We have just been informed, via a copy of the enclosed letter to Mr. Cruz (Cruse), that the long awaited construction of Mt Daniels Drive in the Happy Trails plat, and its connection to existing Mt Daniels Drive will not be required as part of the final plat approval.

RE: LP-06-00038, Happy Trails Plat Requirement for Construction of Mt. Daniels Drive as Point of Access

HAPPY TRAILS
SECTION 6, T. 17 N., R. 19 E., W.M.
KITITAS COUNTY, WASHINGTON
- PRELIMINARY PLAT -

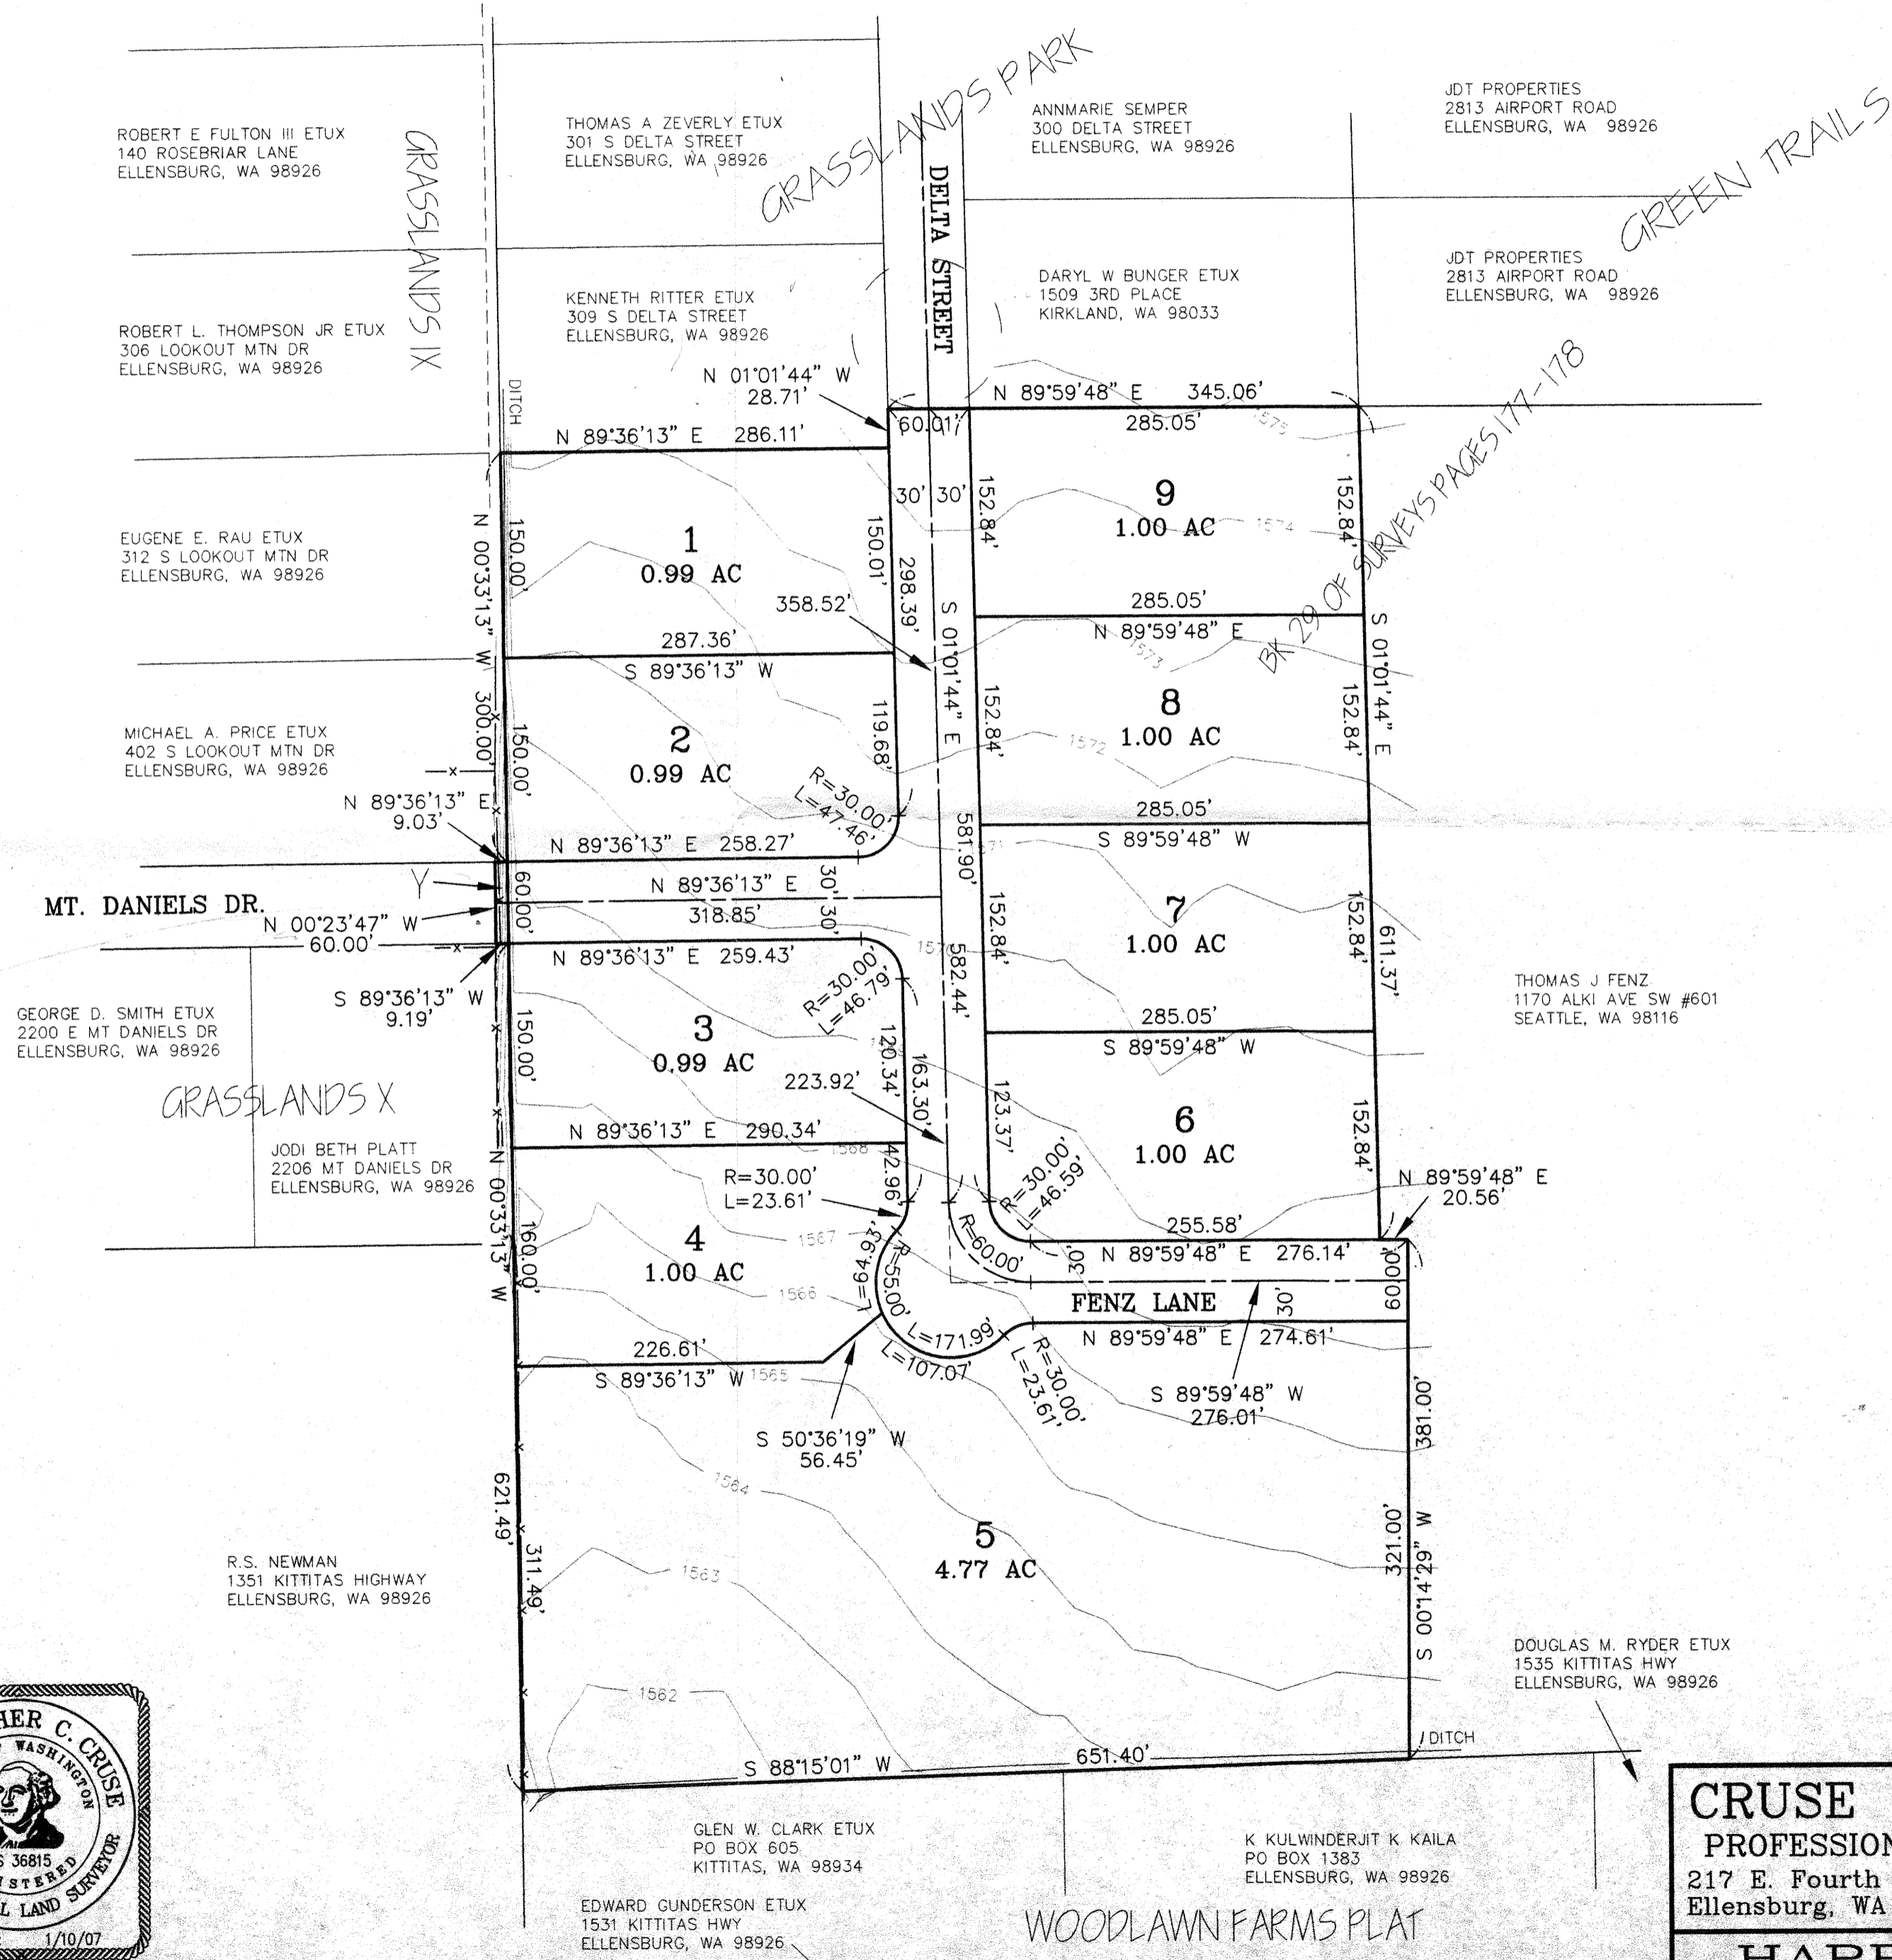
Additionally, emergency vehicles have only one access point, through Quartz Mountain Drive, which could result in longer response times, or if that road is blocked, no access at all. School busses also have only one way in and out.

We sincerely hope that paragraph 16 in the preliminary plat approval resolution (No 2008-23) which says "Access to the plat will be via Quartz Mountain Drive or Mt Baldy Lane..." simply overlooked Mt Daniels Drive as an access point. We ask that Mt Daniels Drive be added to the final plat approval so that it can be constructed as a required access. This would reduce traffic on Quartz Mountain Drive, reduce the danger to residents using the roadway for exercise, and provide an additional access point for emergency responders and for school busses.

As you are aware, an issue surfaced regarding the preliminary plat Happy Trails and the establishment of Mt. Daniels Drive as a point of access as was originally shown in application and the plat submitted. The issue revolved around the absence of documented information that indicated that such an access was no longer necessary. Specifically:

- The record of the MDNS issued for the plat indicates that the plat would have access via Delta Street, Fenz Lane (now called "Mt. Baldi"), and Mt. Daniels Drive;
- The planning commission audio record indicates that they recommend the approval of the application under conditions proposed by staff, and that the applicant agreed to the conditions for approval of building Mt. Daniels Drive to the west property boundary as shown in the preliminary plat;
- There is no audio or written record in the file indicating from staff in verbal or written recommendations, or within the Board of County Commissioners Findings of Fact, that relief should be granted from the condition of building Mt. Daniels Drive for final plat approval;
- The record shows the preliminary plat as having Mt. Daniels Drive, which can be considered a significant improvement within the proposed plat.

For these reasons I have decided that Mt. Daniels Drive does not have to be constructed at this time within the Happy Trails plat for final consideration and approval. Although the right of way shall be designated on the final plat, and the road shall not be required to be constructed at this time, there shall

be curbs provided at the east end of the Mt. Daniels Drive right of way where it connects with Delta Street, and the right of way shall be paved 10 feet into the Mt. Daniels Drive right of way. The balance of the right of way may remain vegetated. There shall be on the face of the plat the existence of the Mt. Daniels Drive right of way and its boundary, and a note that all buildings requiring or not requiring building permit will meet zoning and other required setbacks in the event that the County determines that the road is necessary link to the County's transportation system. Such a note shall also be included in any title report on any property adjacent to the right of way.
